14th August 2023

**RE: OBJECTION TO OUTLINE APPLICATION FOR ERECTION OF DETACHED DWELLING
AT: LAND ADJ. TO 6 REINWOOD AVENUE, QUARMBY, HUDDERSFIELD, HD3 4DP**

LPA REF: 2023/91963

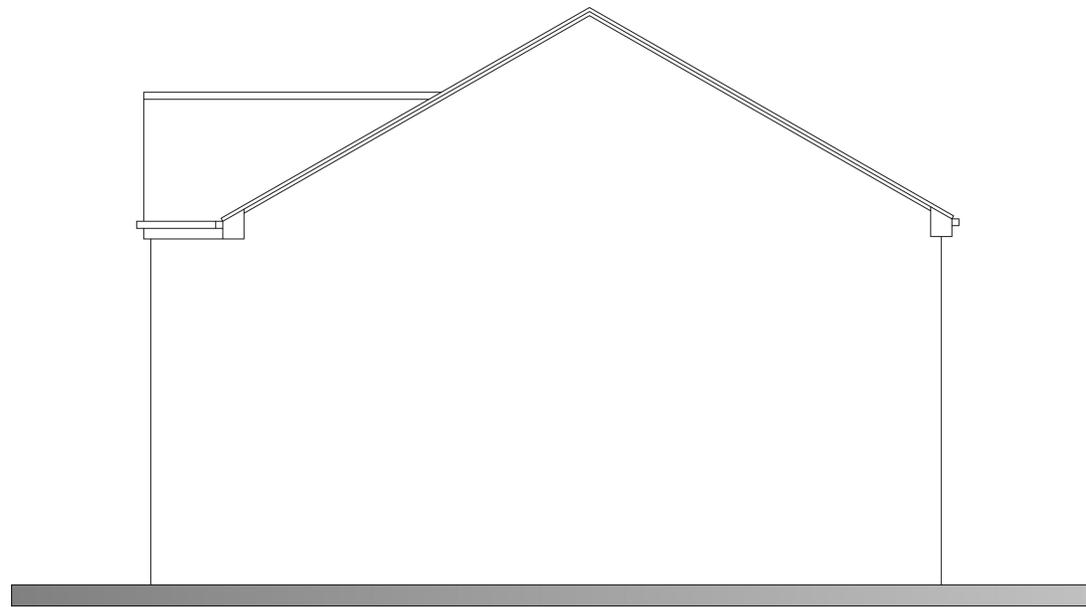
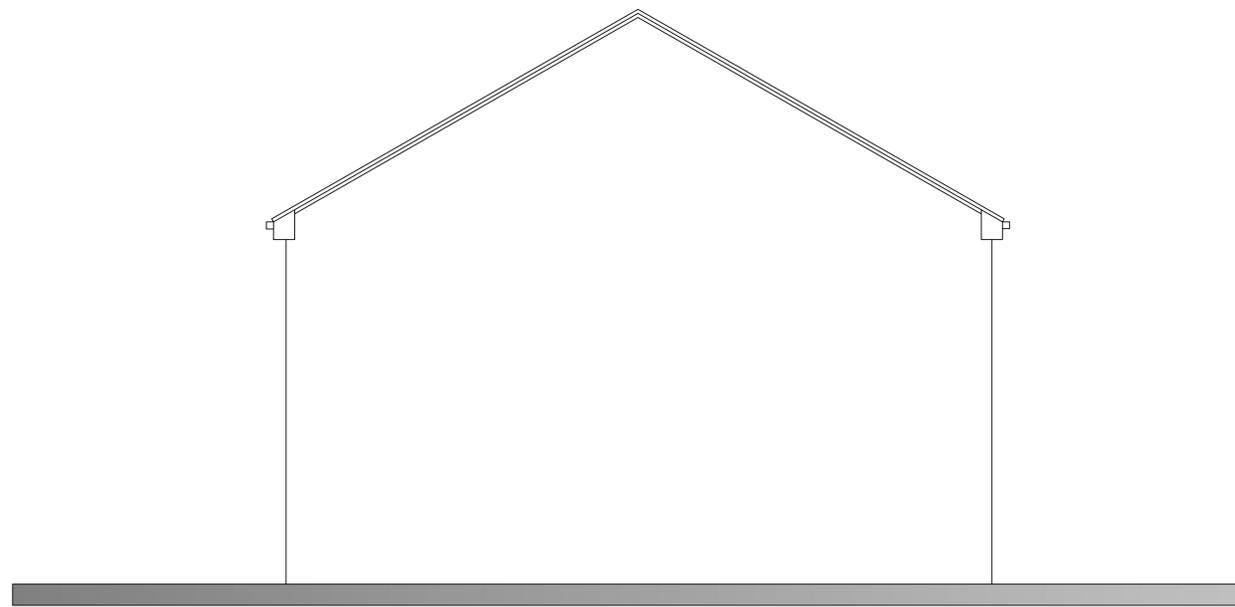
Turning to the issue of scale, the recent plan submitted illustrates a large two storey dwelling with projecting front gable and extensive glazing. Although it is accepted that the matter of 'appearance' is reserved for a future application, the scale of the dwelling as shown with standard height eaves and a projecting front gable would be entirely out of keeping with the roof designs and eaves heights of existing dwellings on this side of Reinwood Avenue. Moreover, the large scale would result in a significantly bigger massing and over-dominance when compared with neighbouring dwellings, again to the detriment of the established urban grain and character of the street scene.

The topography of the site would also result in the proposed dwelling being situated at a higher level to our clients’ property – approximately 1 metre. The proposed dwelling has now been confirmed to be two storeys in height and would have a height of 8.5 m (9.5m taking into account the level differences) and a depth of 11.2 m from front to back.
